Re: Planning application 2016/0164

Proposal: Proposed single storey rear/part side extension

Location: Meadowside, Rimington Lane, Rimington BB7 4EA

4944 - 02

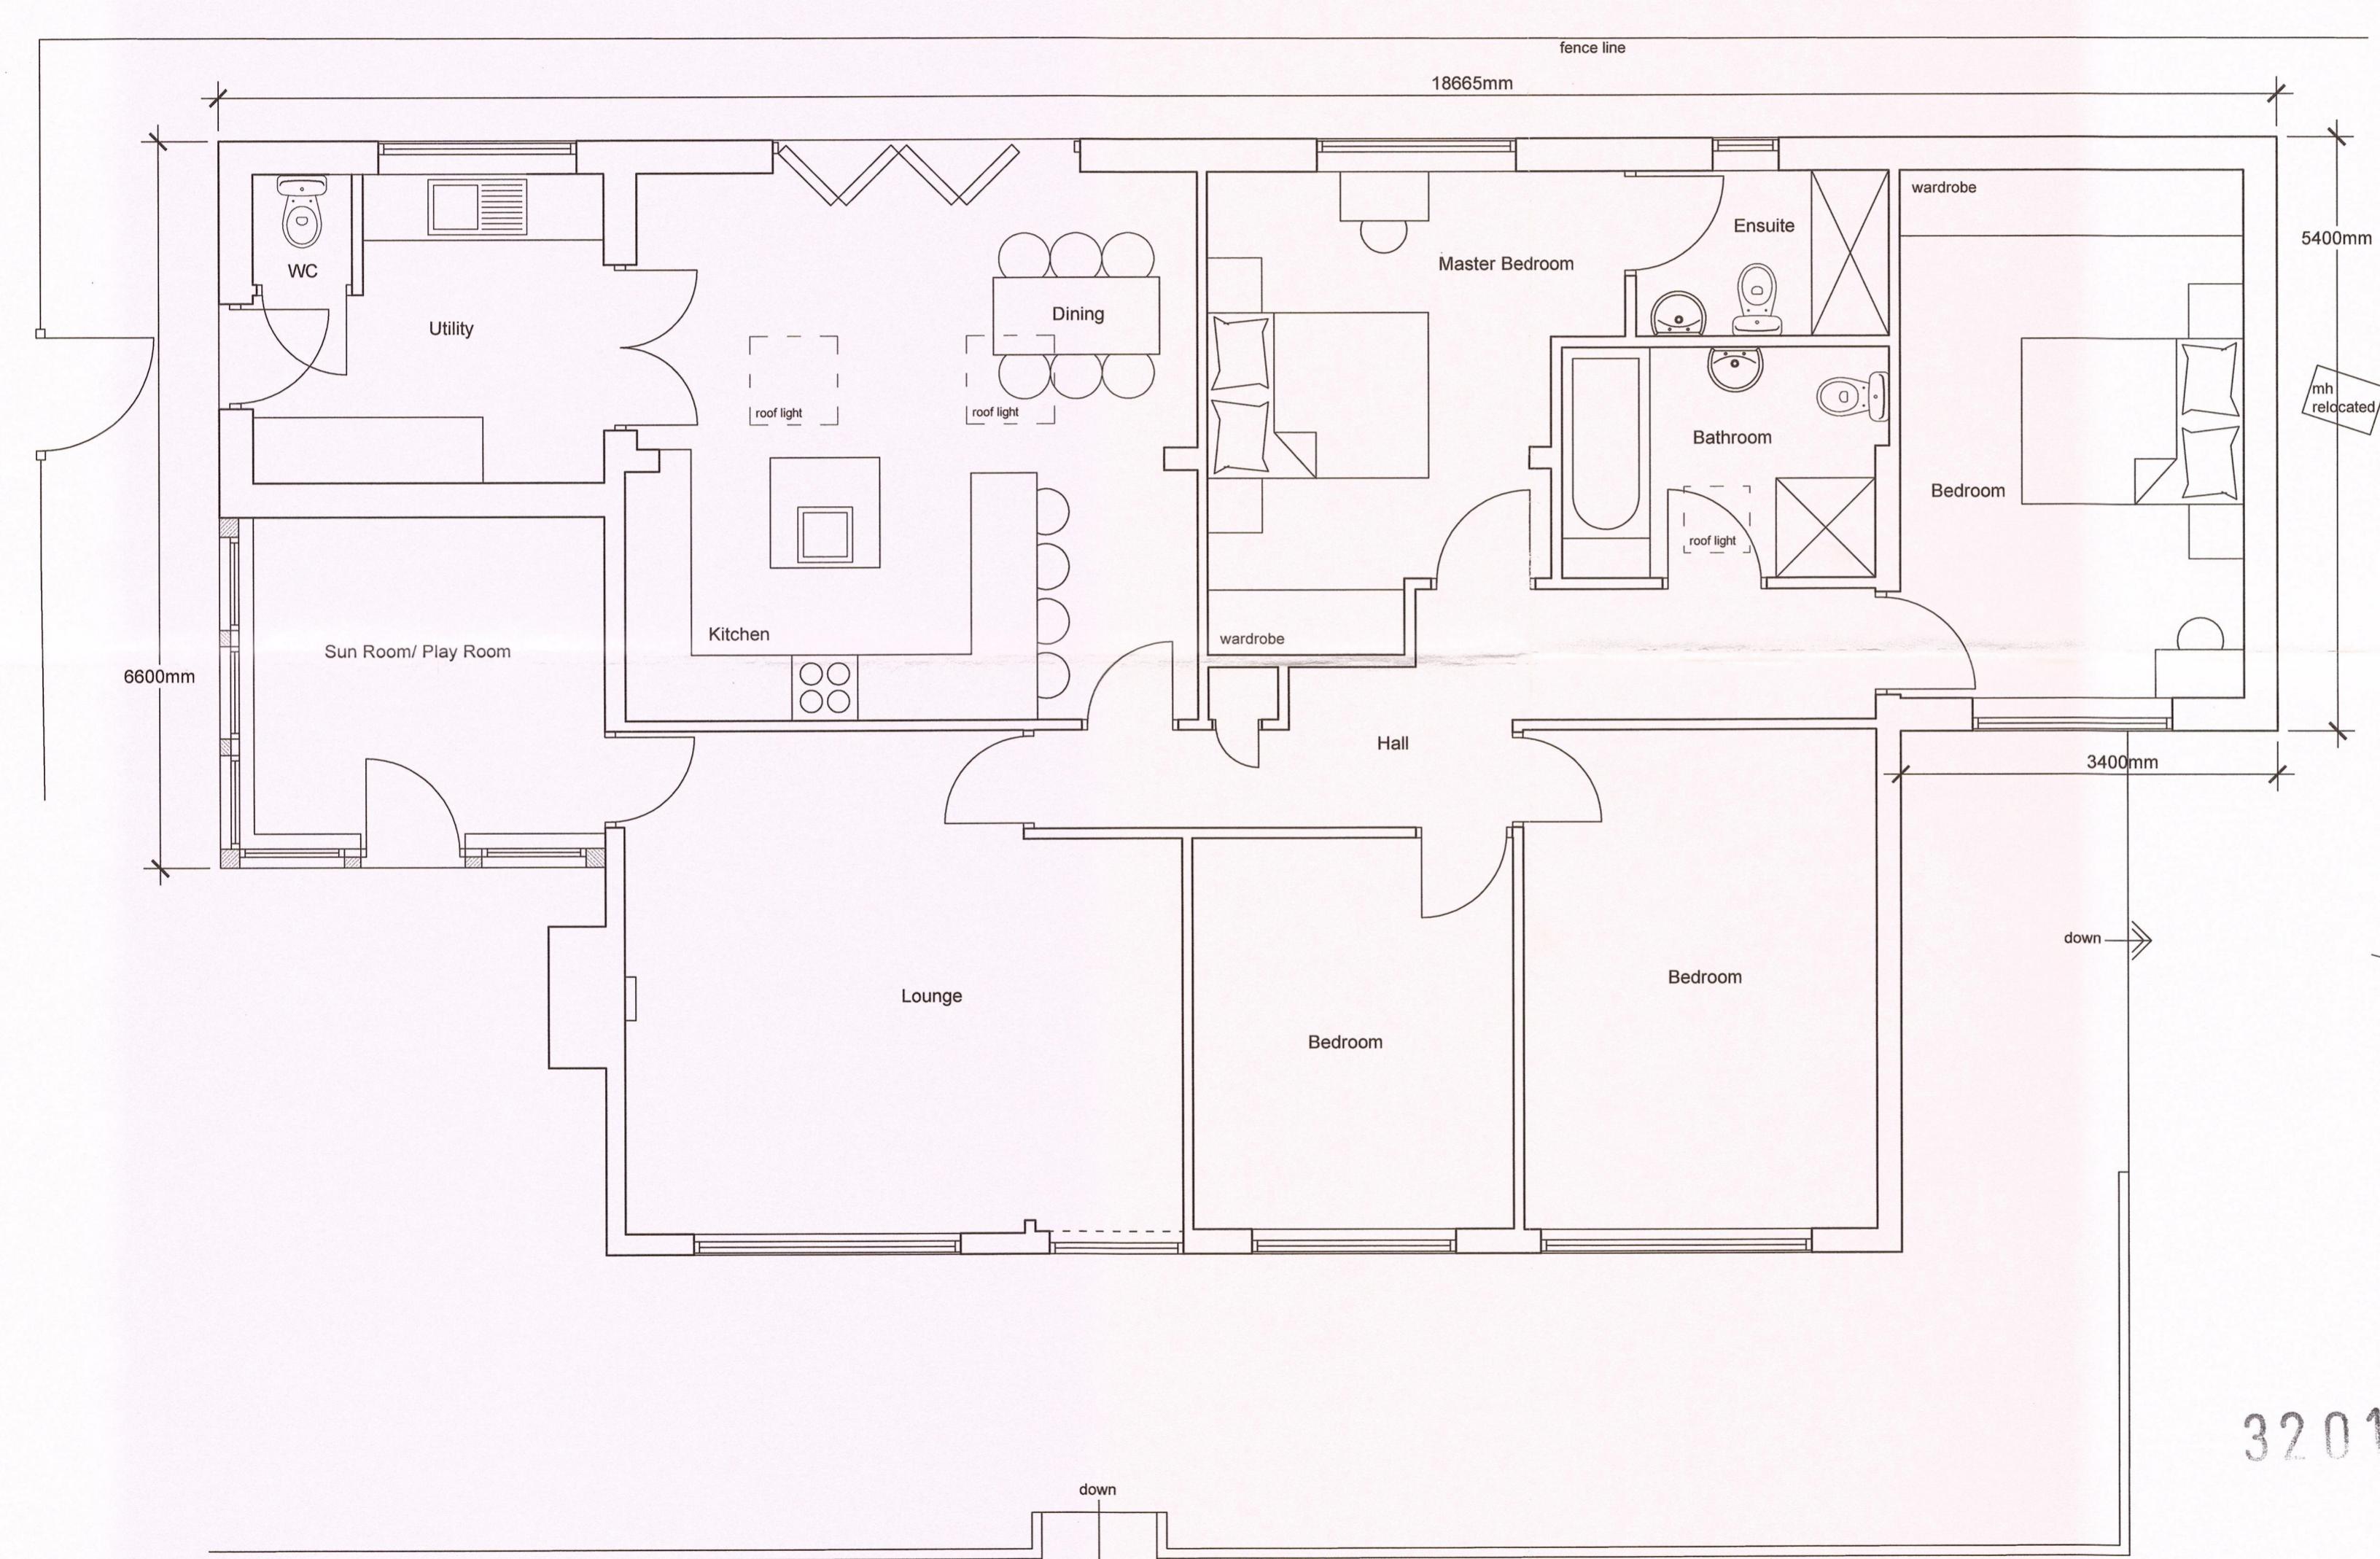
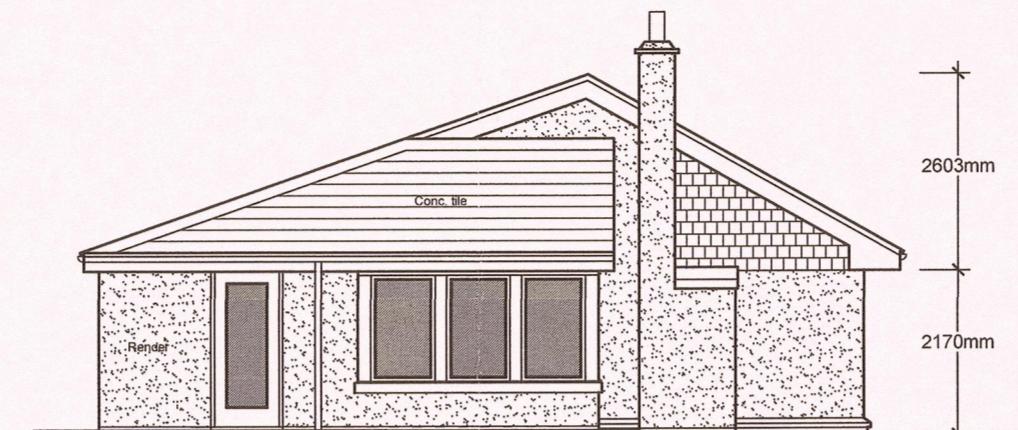
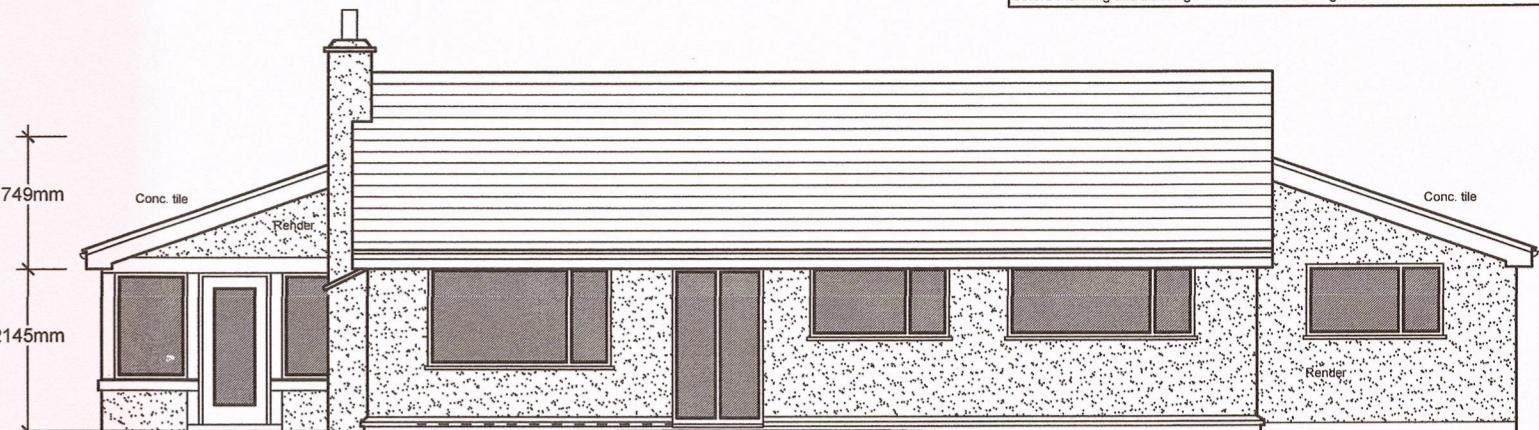
The proposal adds additional single storey living space to the dwelling, which will result in an increase in bedrooms from the existing three to four bedrooms. Consequently I have treated this application as increasing the dwelling to a 4+ bedroom property. Under the terms of the 'Joint Lancashire Structure Plan – SPG Access and Parking' a minimum of three parking spaces of appropriate size and location should be provided within the site.

Whilst no parking area has been shown on the plans submitted the applicant has indicated on the application form that the proposed works will not affect the existing car parking arrangements. However I would ask that the applicant provides a plan showing the parking layout.

Should this plan show appropriate, on-site parking provision to the Highways Development Control Section's satisfaction then I would have no objection to the proposal on highway safety grounds.
